City of Albuquerque Stormwater Construction Site Inspection Report

ESC File No.	J10E048	Project Name:	FedEx Stockpile - Tract D		
NPDES Id. No.	NMR1002UH	Location:	Fortuna Rd. NW		
7/14/2021	Owner			Contractor	
Operator	Yankee Fans, LLC.		Franklins		
Contact name & title	Angleo Brunacini		John Ellis		
e-mail	abrunacini@brunacini.com		John.Ellis@feinm.com		
Contact Phone #	505-991-2233		505-975-2878		
COA Inspector	Thomas Evans		Start/End Time:	10:35 AM-10:45 AM	
Construction Phase:	Stabilization				
Type of Inspection:	Regular	Storm Event	Past Storm Event >0.25"	311/Complaint	Follow Up
Weather at time of inspection?	clear		Temperature:	~ 82	
Estimated date of last storm 0.25" or greater	7/6/2021

TRACT D MERIDIAN BUSINESS PARK ALBUQUERQUE, NM 87121	DRAWN BY pm
	STOCKPILE PLAN	DATE 3-12-2020
	TERRA WEST, LLC 5571 MIDWAY PARK PL NE ALBUQUERQUE, NEW MEXICO 87109 (505) 858-3100 www.tierrawestllc.com	DRAWING
		SHEET # ST-1
		JOB # 2019025

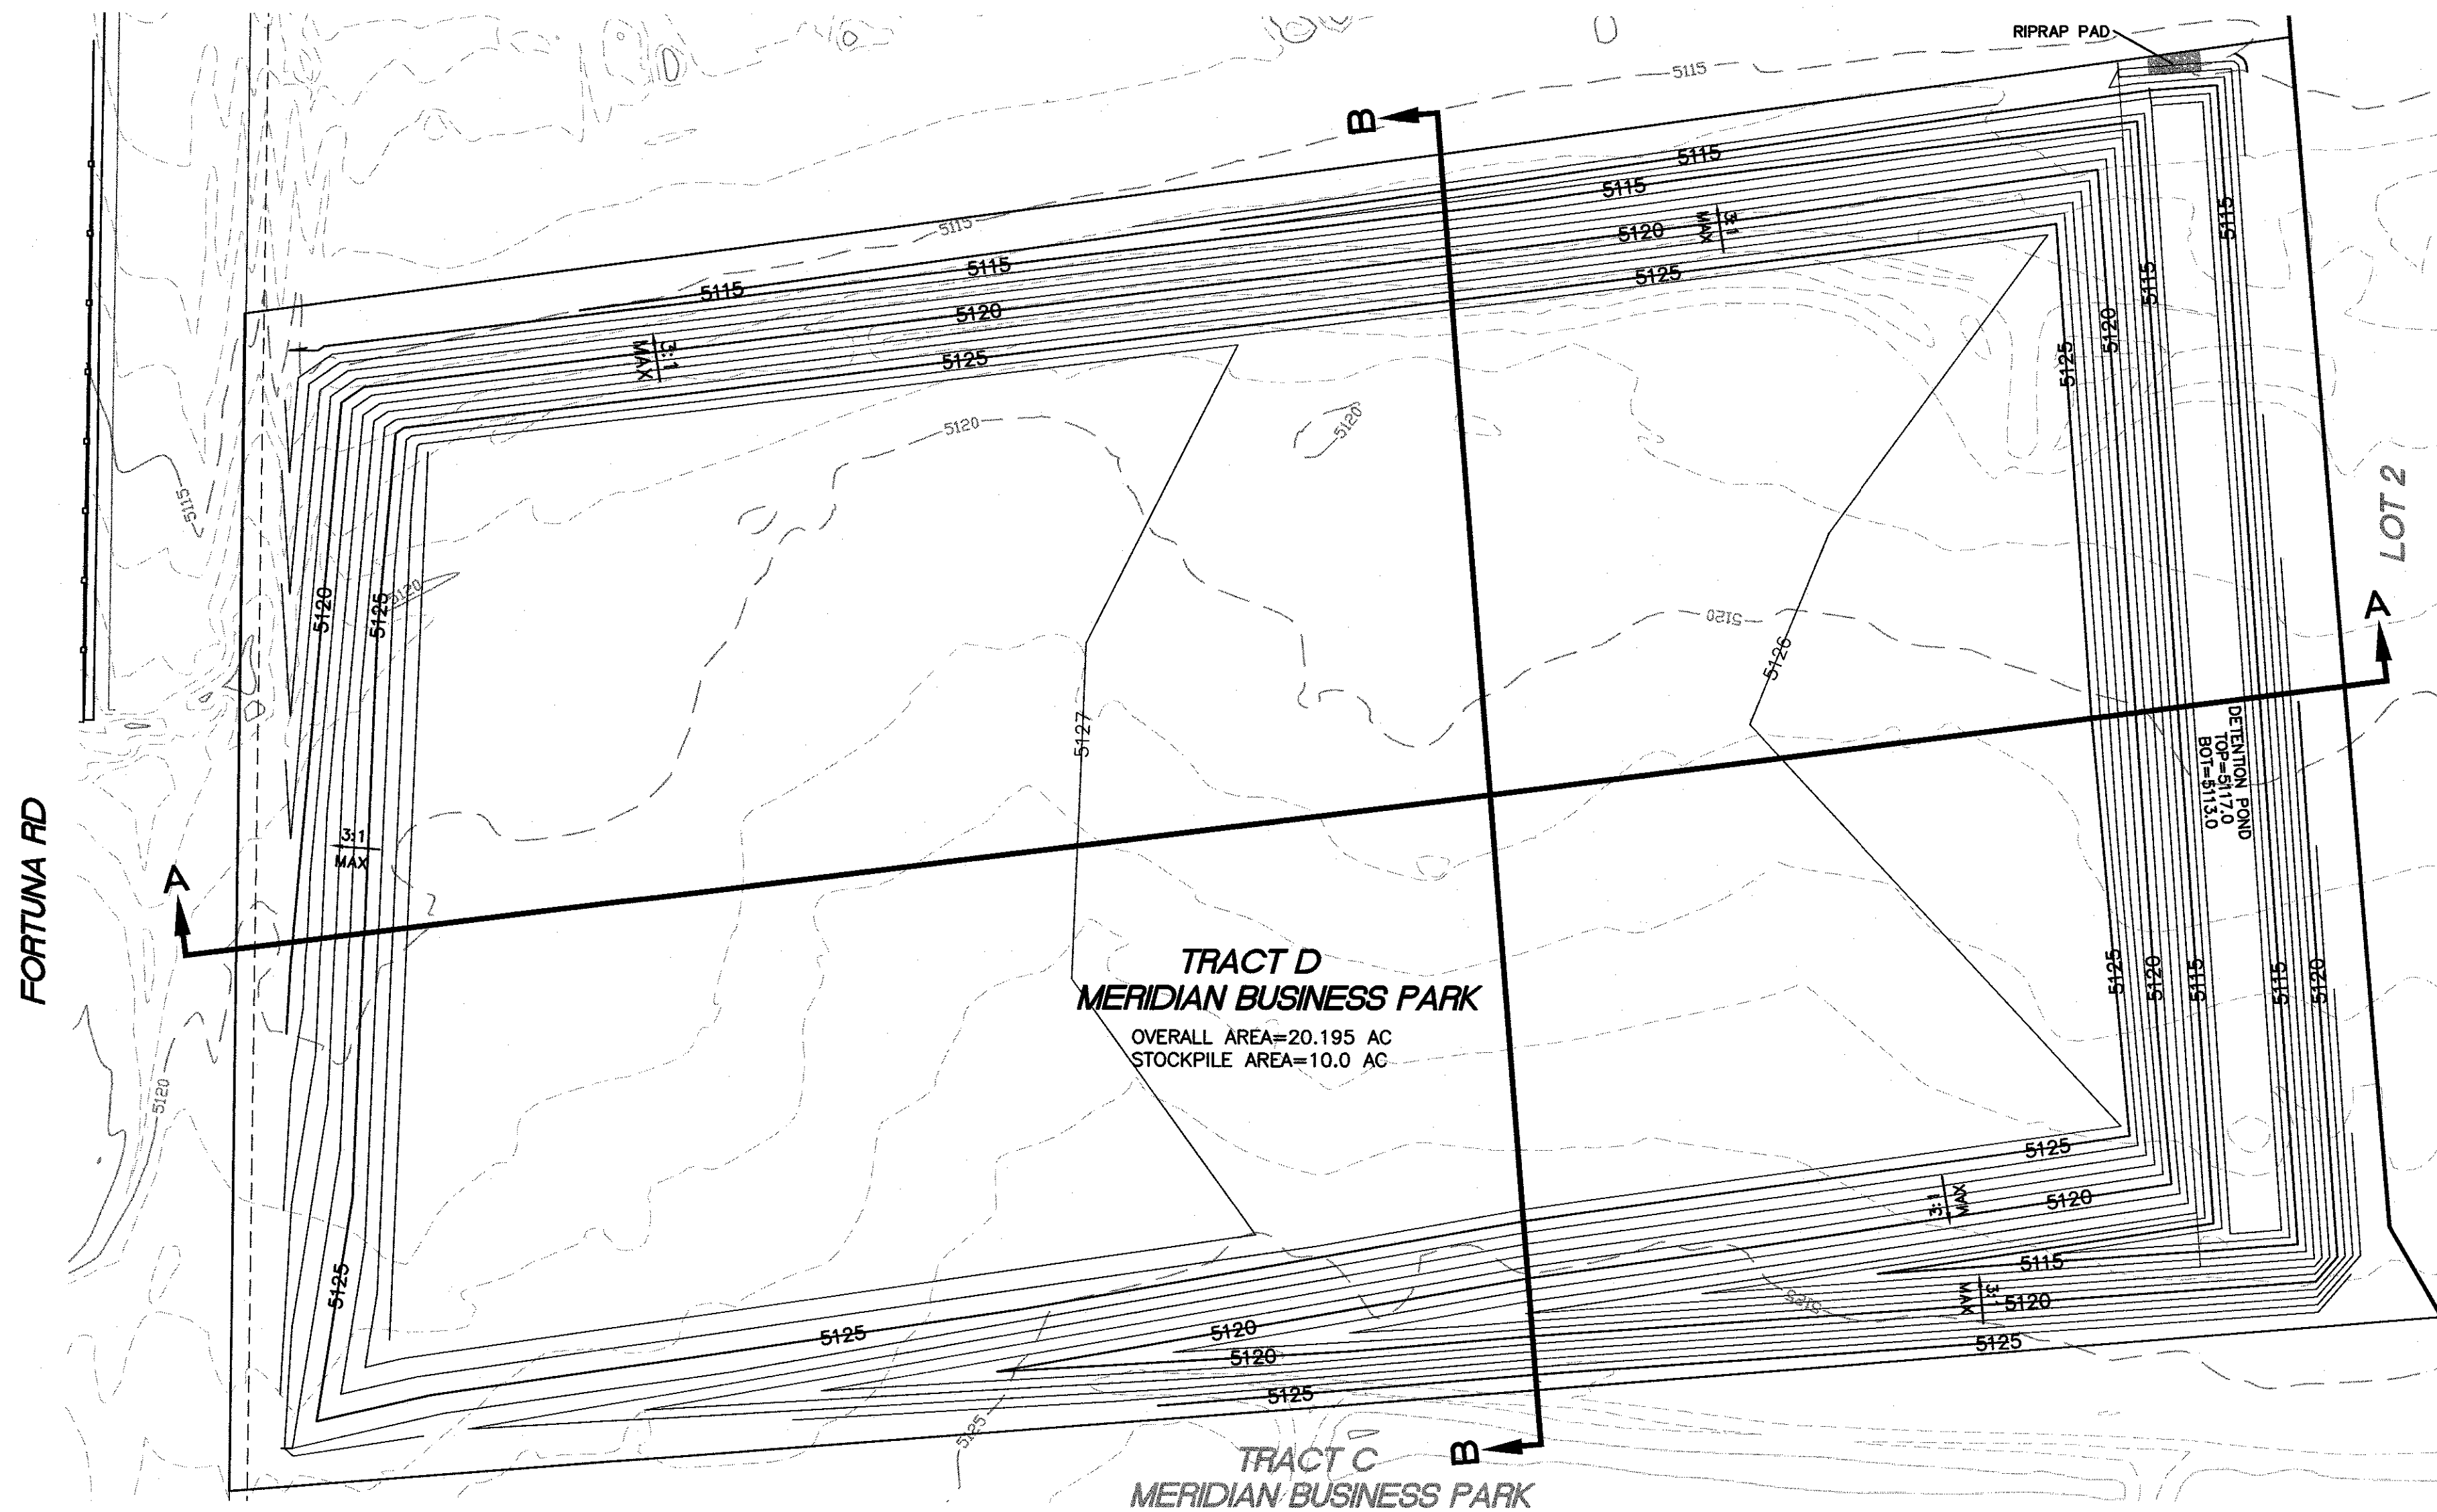
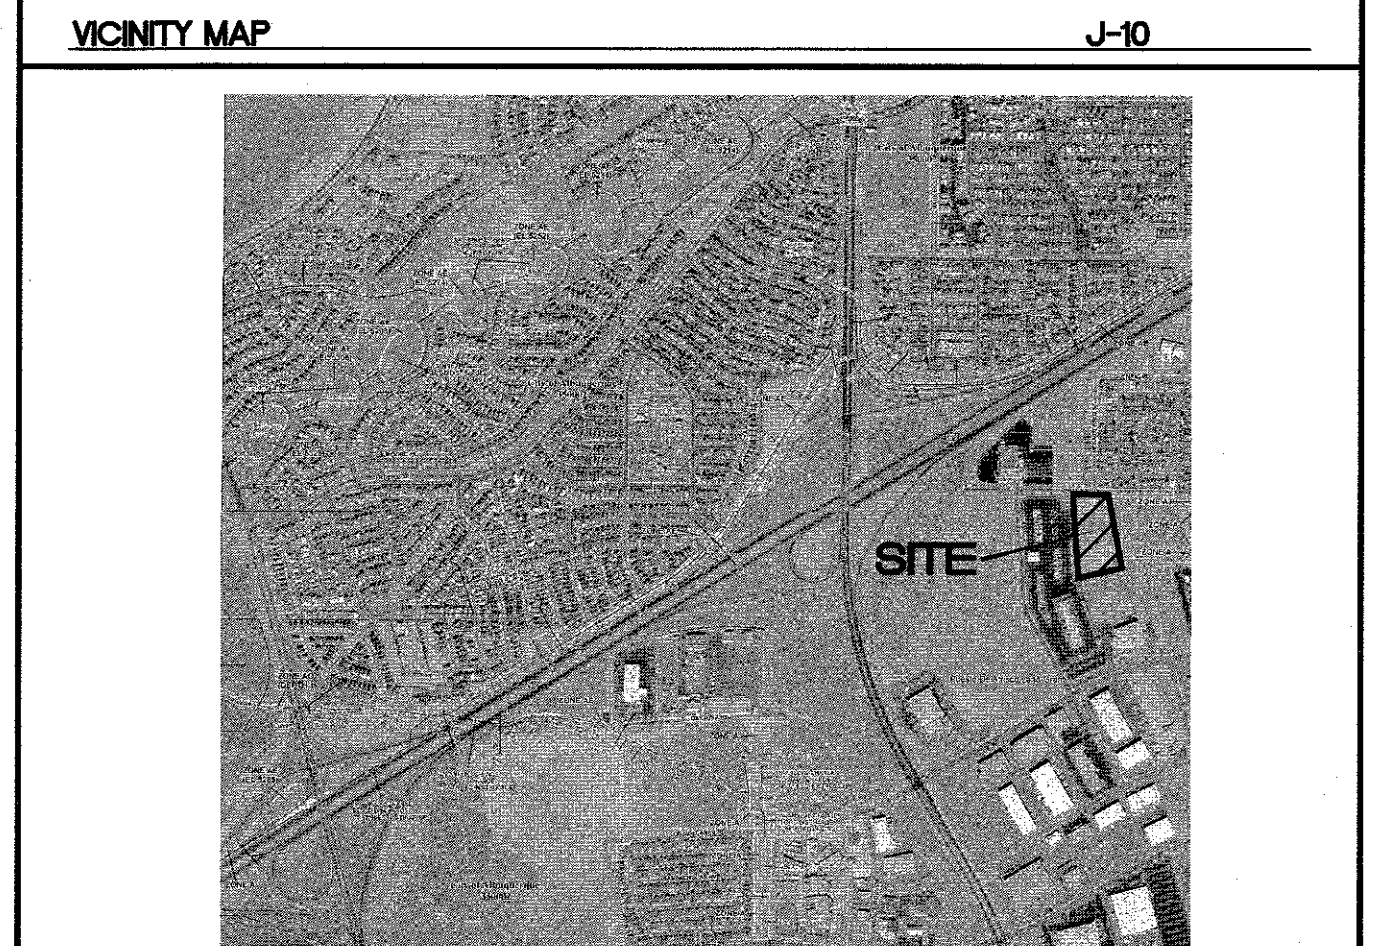
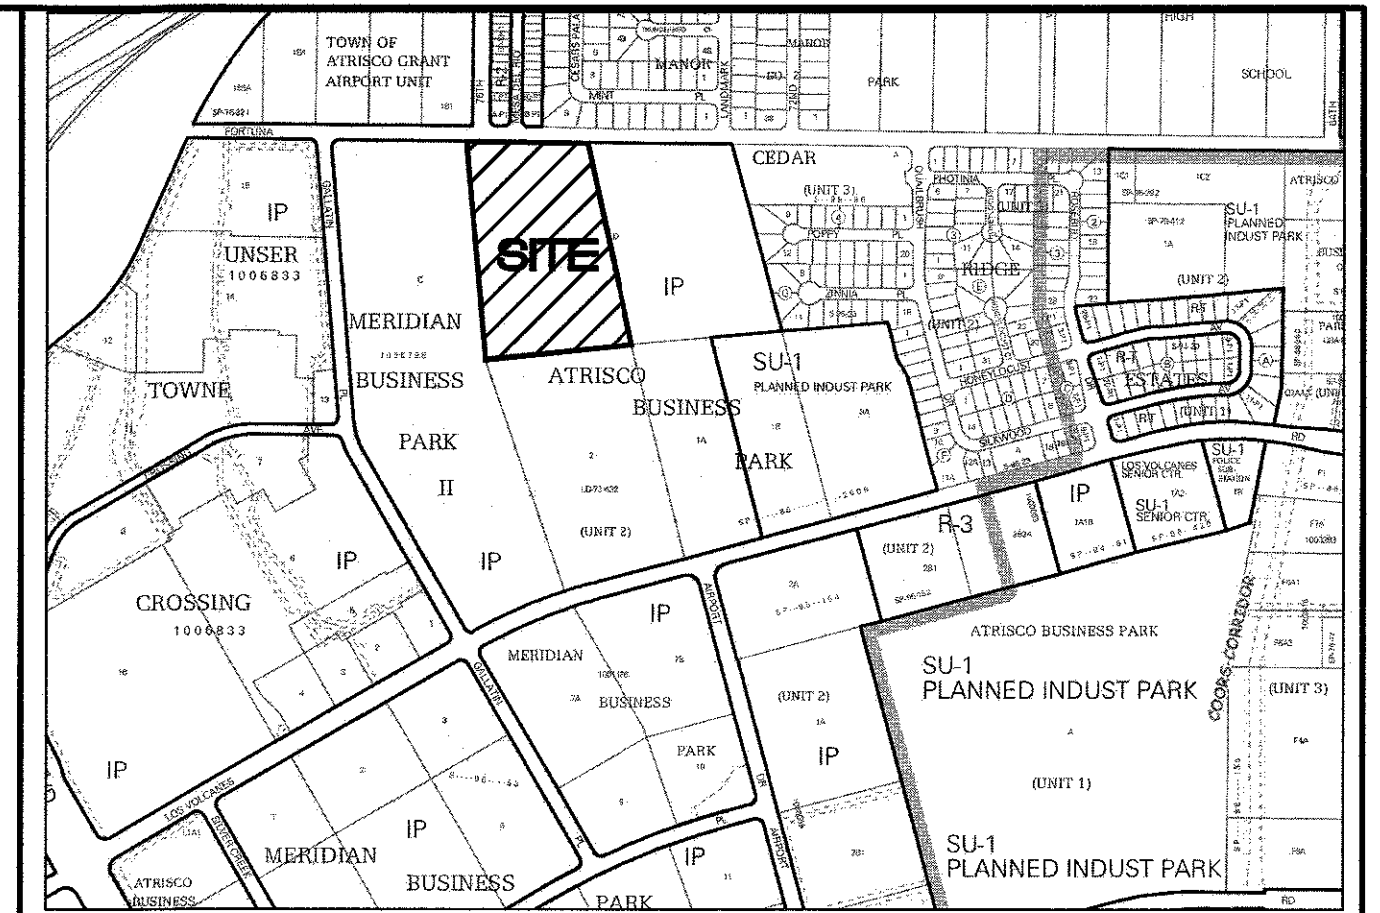
Item Number	Deficiency/ Corrective Action				
1	Silt fence down in areas along East side. Repair/maintain silt fences				
2	Site is not stabilized. Implement stabilization controls to meet set forth in CGP 2.2.14.				
3					
4					
5
